Application for Removal or Variation of a Condition following Grant of Planning Permission or Listed Building Consent

Conversion of existing building into 3 No. one bedroom townhouses.

20/02169/LBC

Drawing No.
 7526 MEIN-XX-XX-DR-A-20-007

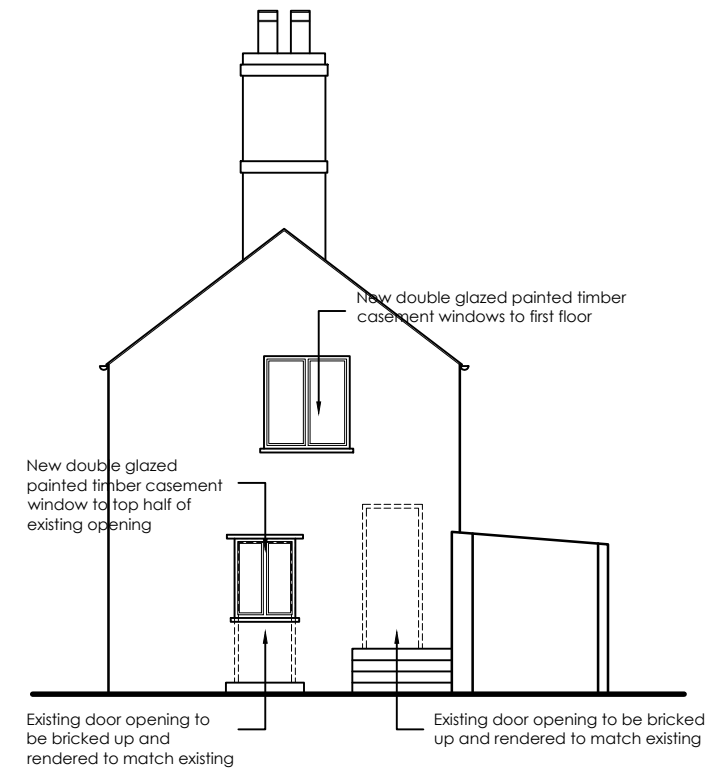
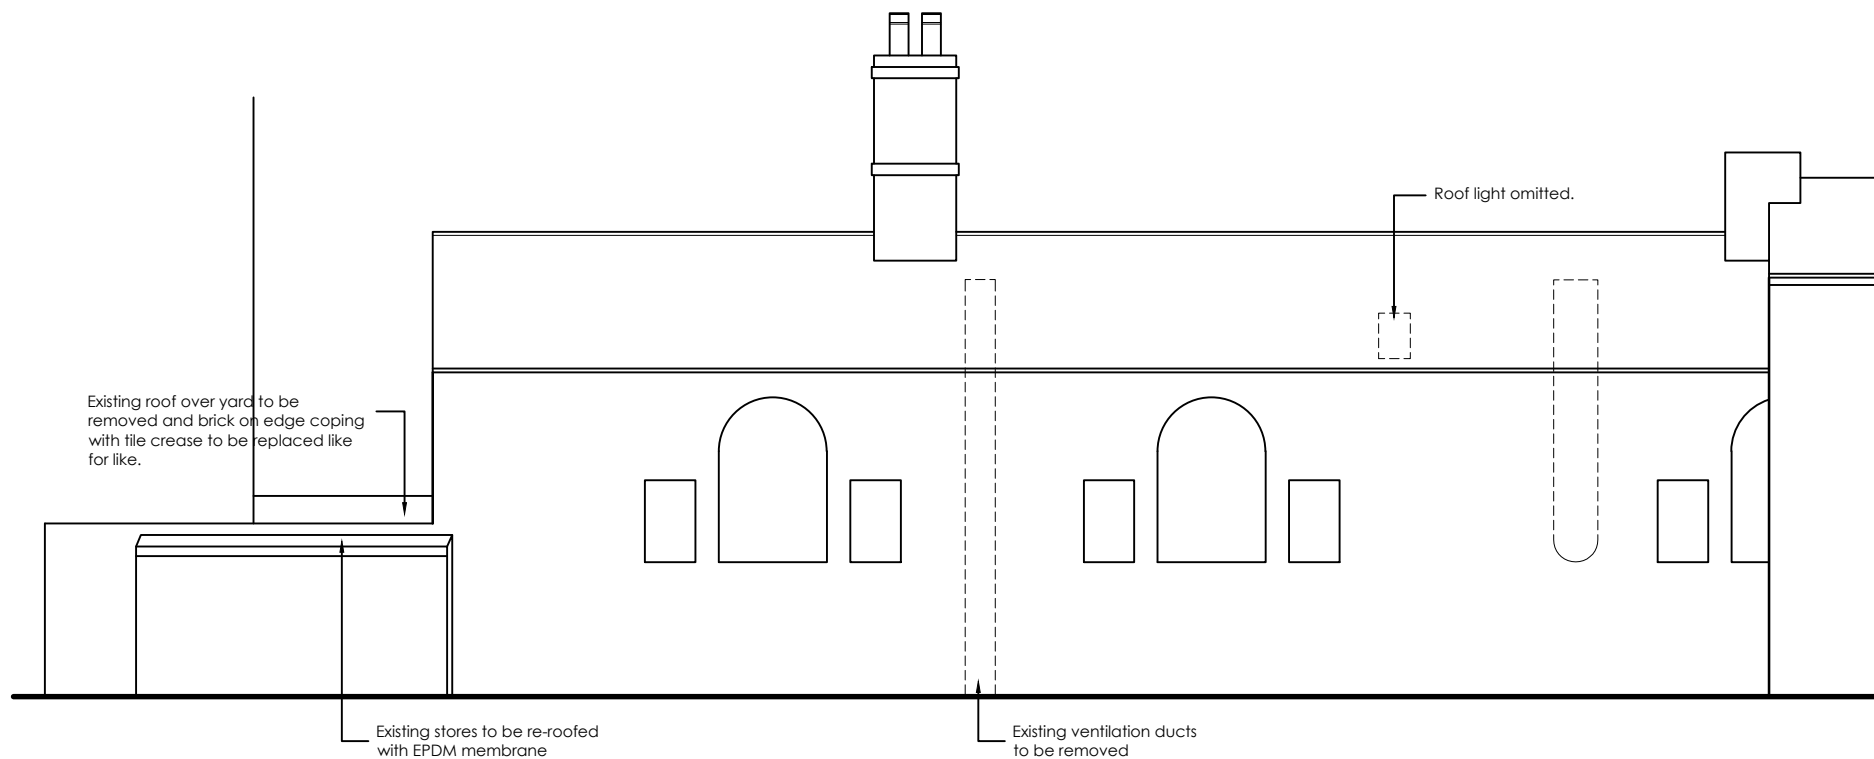
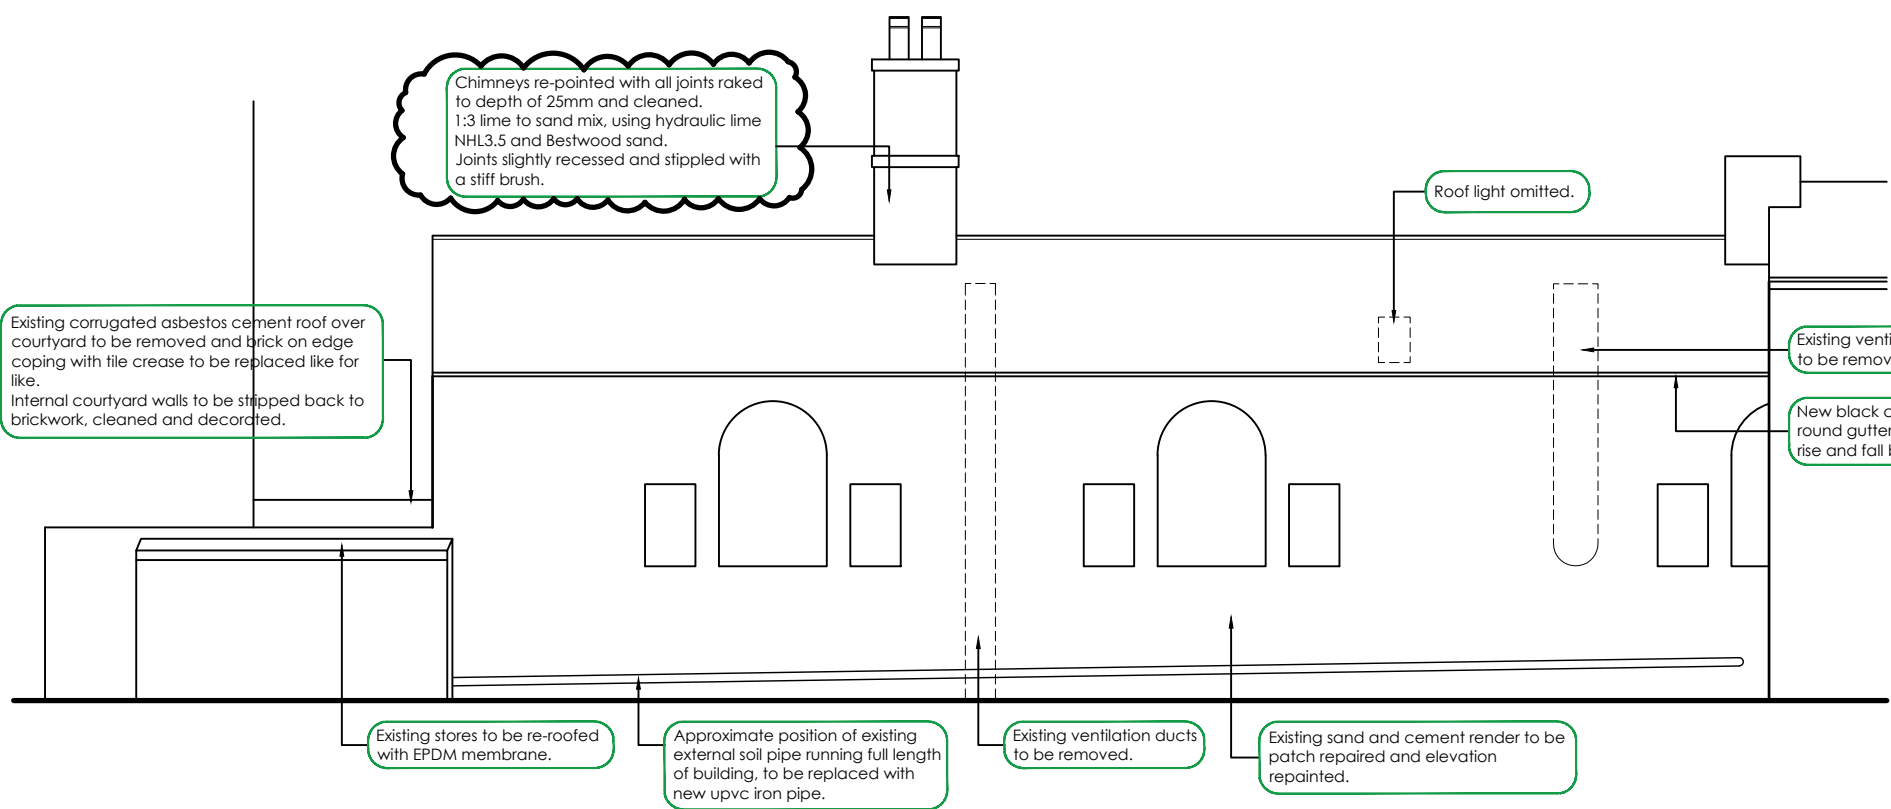
To suit the works undertaken on site as approved by the conservation officer.
Specifically the rebuilding of the external courtyard wall using reclaimed and new red engineering bricks with lime render finish to match building.
Due to the condition of the existing bricks not being suitable for reuse.

Change the reference to latest drawings and revisions, superseding
7526 MEIN-XX-XX-DR-A-20-003 Rev P4 Proposed floor plans
and
7526 MEIN-XX-XX-DR-A-20-004 Rev P5 Proposed elevations
with
7526 MEIN-XX-XX-DR-A-20-006 Rev P3 Proposed floor plans
and
7526 MEIN-XX-XX-DR-A-20-007 Rev P3 Proposed elevations.
